App No: Y/30/19/DOC

Address: Land East of North End Road Yapton BN18 0AG

Proposal: Approval of details reserved by condition imposed under ref Y/49/18/PL relating to Condition Nos 11 - landscaping, 14 - dustbin enclosure, 19 - electric car charging and 21 - external lighting.

Condition 21 – Lighting

HALF LANTERN BLACK LED 600 HILO

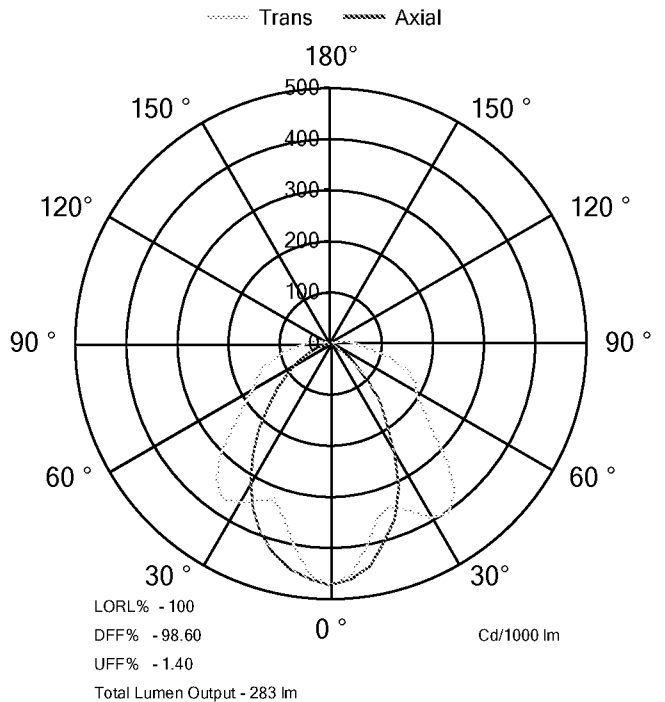
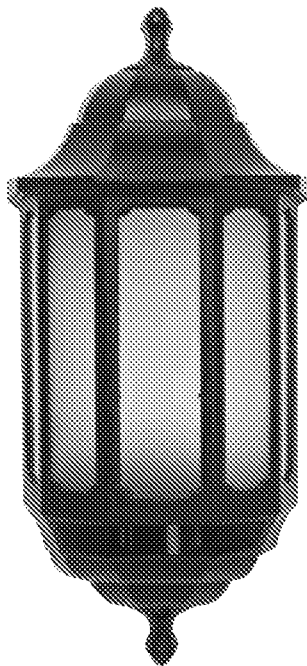
To ensure that there is no upward light spill that may cause disturbance to bats in the local area we require that the external lighting used does not direct any light upwards. Unfortunately the lights which have been chosen do not comply with this. We require that different lighting is used which is directional and hooded if required.
